From: Barry Holden [mailto:edwardbholden@yahoo.co.uk]
Sent: 10 July 2012 11:47
To: Claire Booth
Subject: Planning application 3/2012/0525

Our council object to the above application on the following grounds:

PROPOSED MACHINERY/TRACTOR SHED

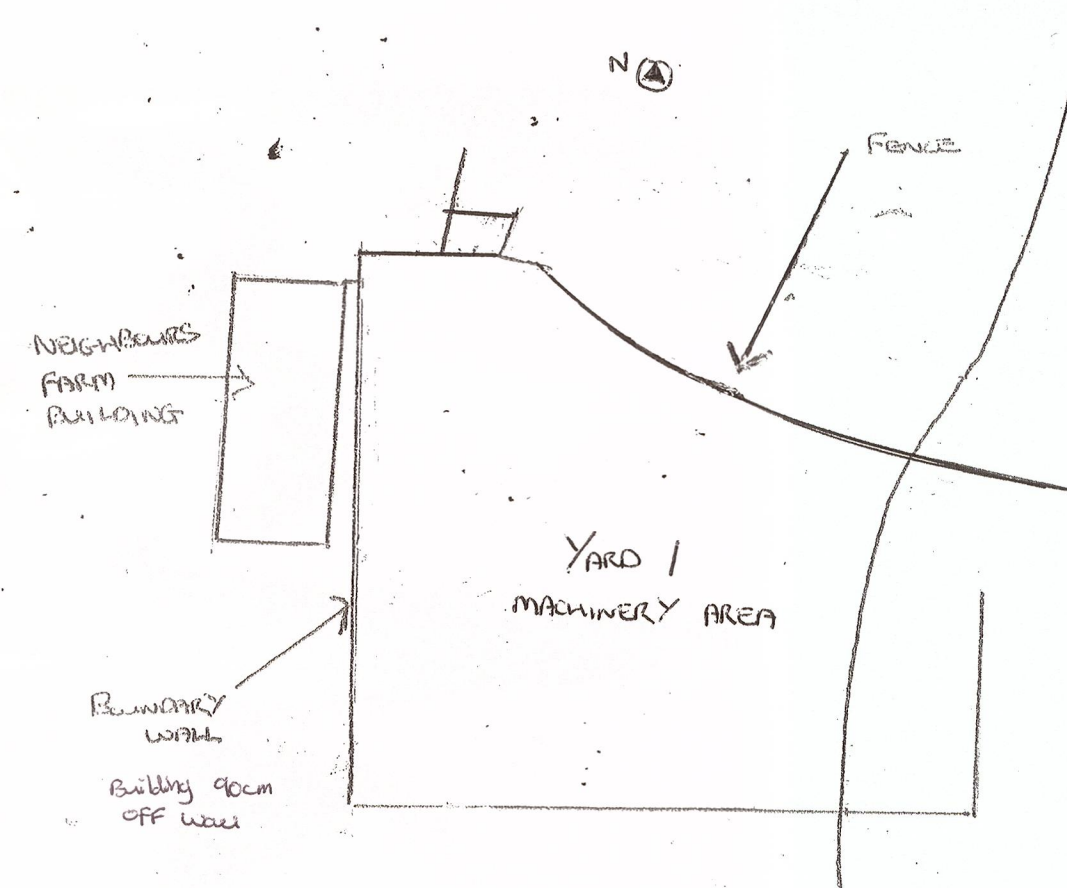
- The plan for the shed is in a position away from the other agricultural buildings rather than being adjacent and integral.
- The location is adjacent to a barn which has been given planning permission for a house.
- The applicant has failed to justify the use of his planned shed.
